Current Zoning: N1-A (neighborhood 1-A)  
Proposed Zoning: R-12MF(CD) (multi-family residential, conditional)

Approximately 19.91 acres located on the east side of North Tryon Street, east of Pavilion Boulevard.

The petition proposes a residential community containing a maximum of 200 multi-family dwelling units and, any incidental and accessory uses permitted in the R-12MF zoning district.

RZ1.00

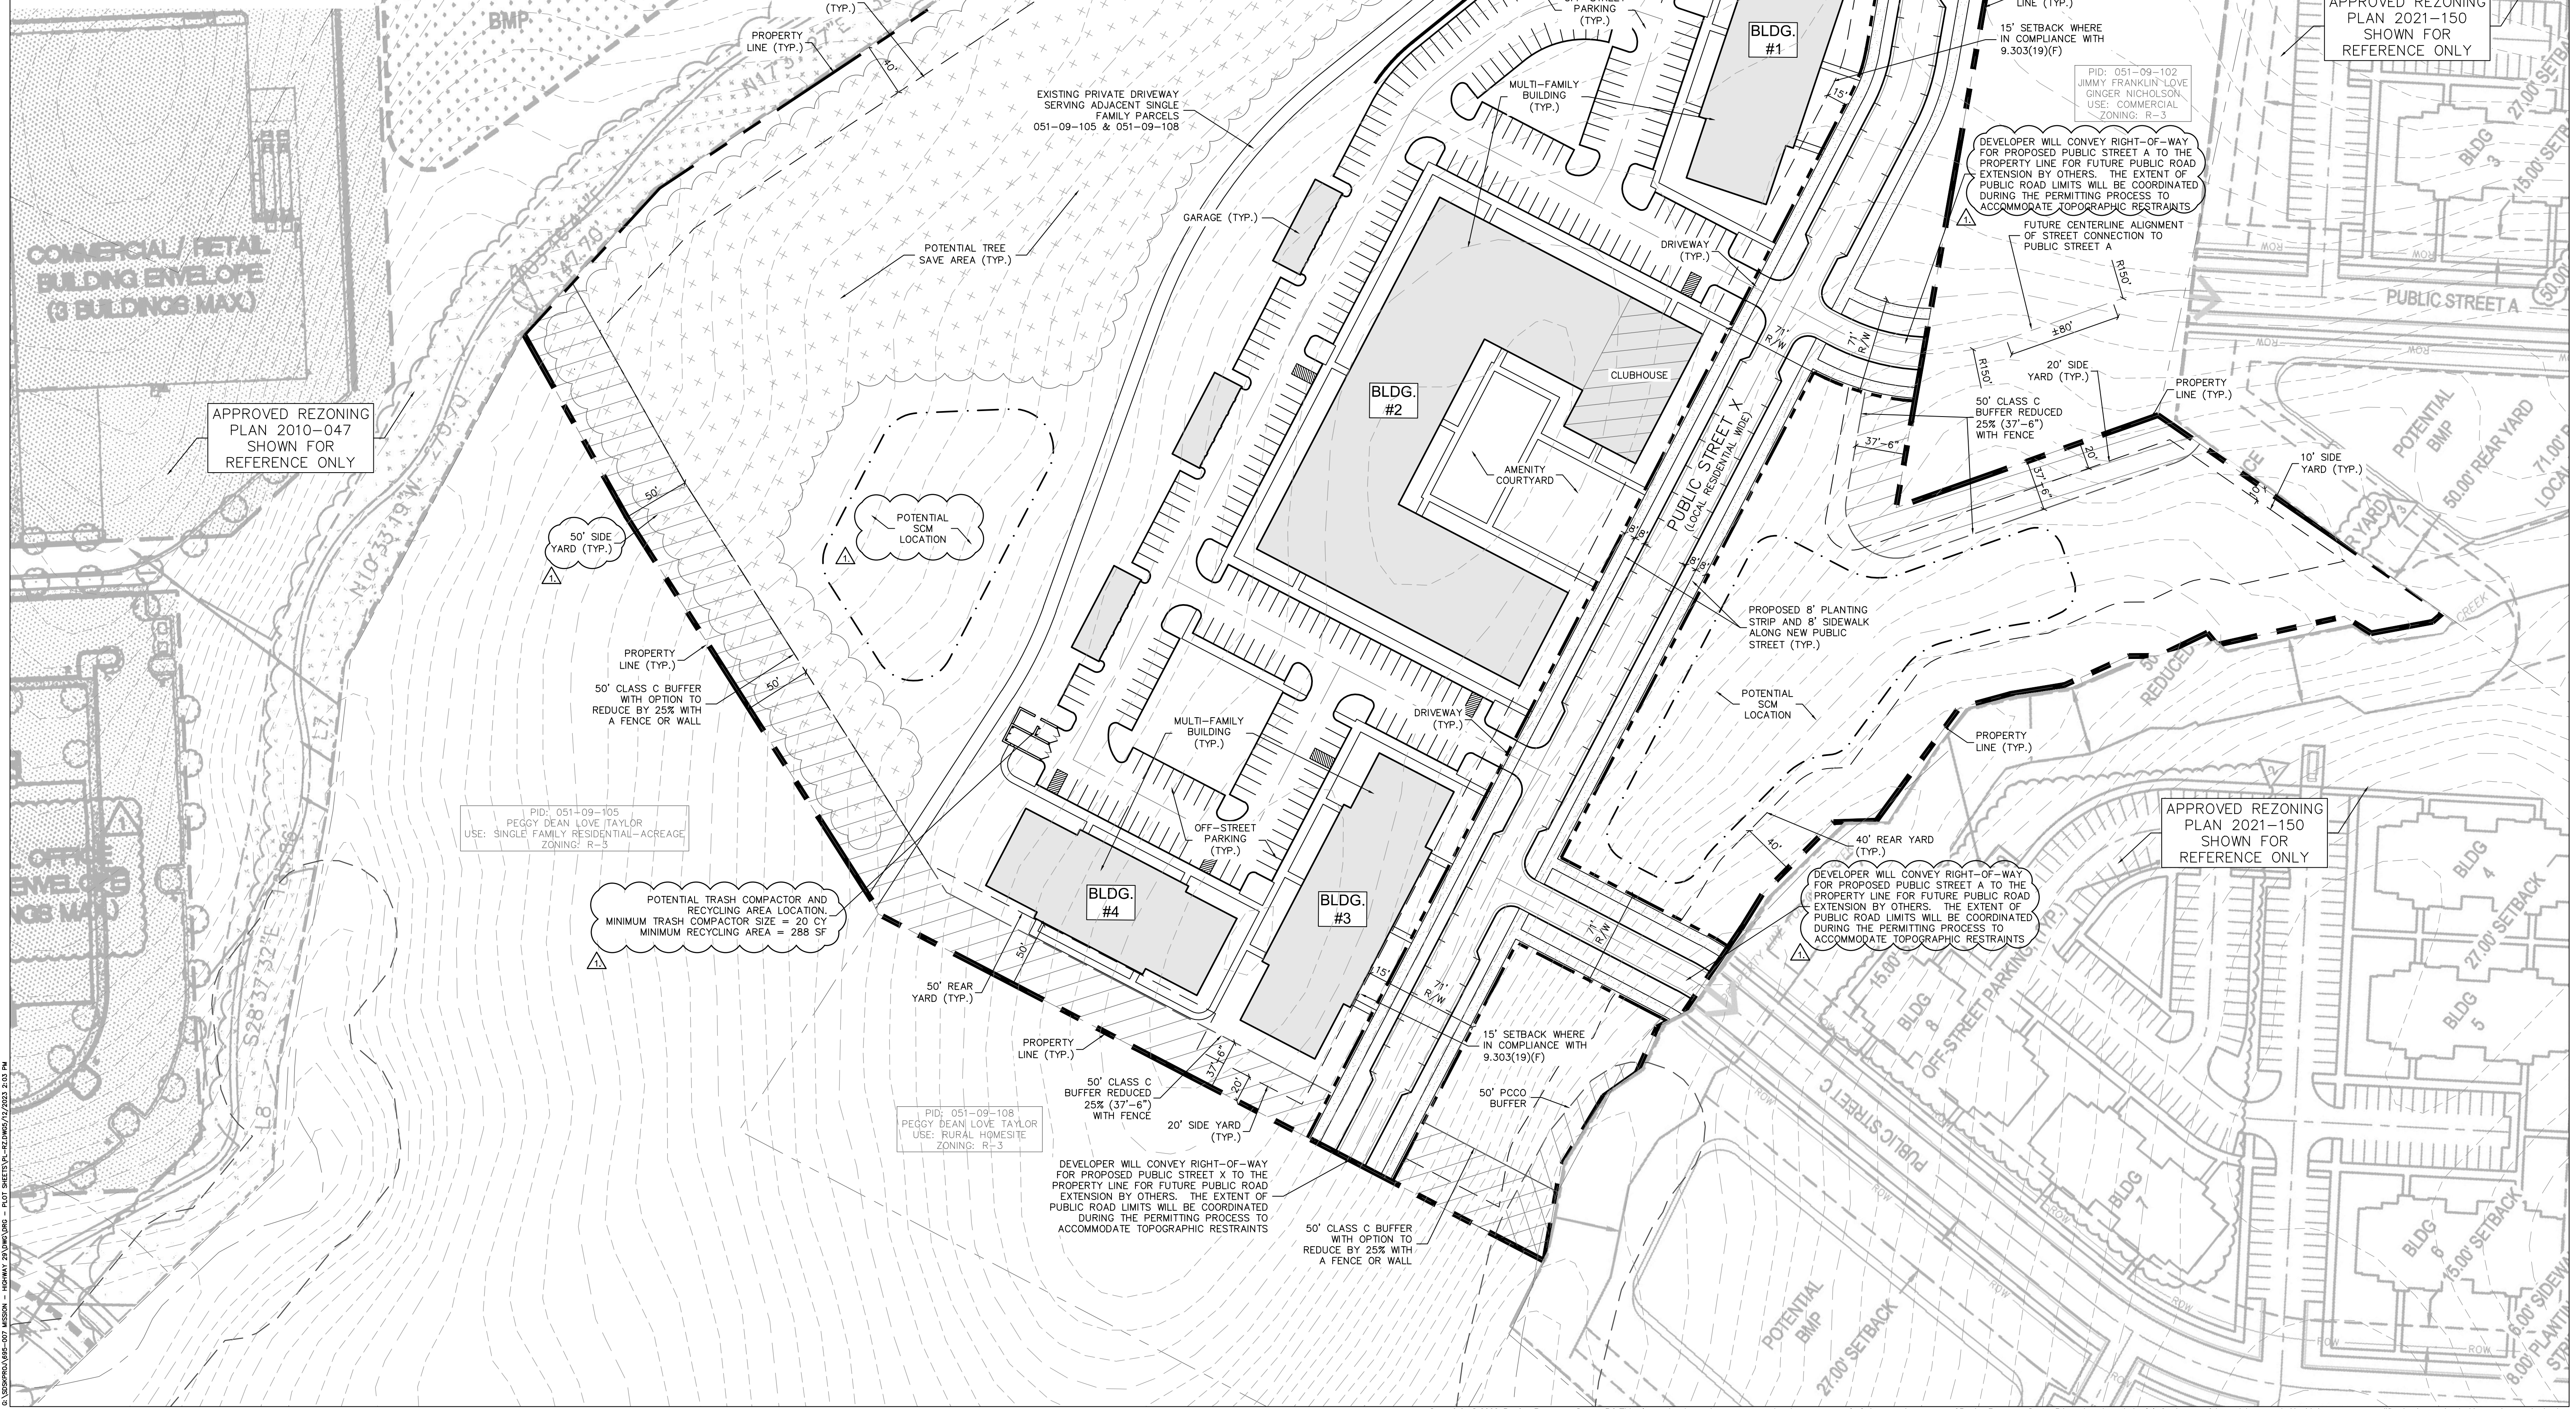
1. Add a conditional note specifying "All transportation improvements will be approved and constructed before the site's first building certificate of occupancy is issued. The petitioner may phase transportation improvements if said improvements and phasing are explicitly described in site plan notes."
2. ~~Revise site plan and conditional notes to commit to relocate proposed site access to the west along US 29 and to coordinate site access location and median extension limits with NCDOT. Site plan shall label and dimension the change along with adding conditional notes committing to the coordinating with NCDOT.~~ Addressed
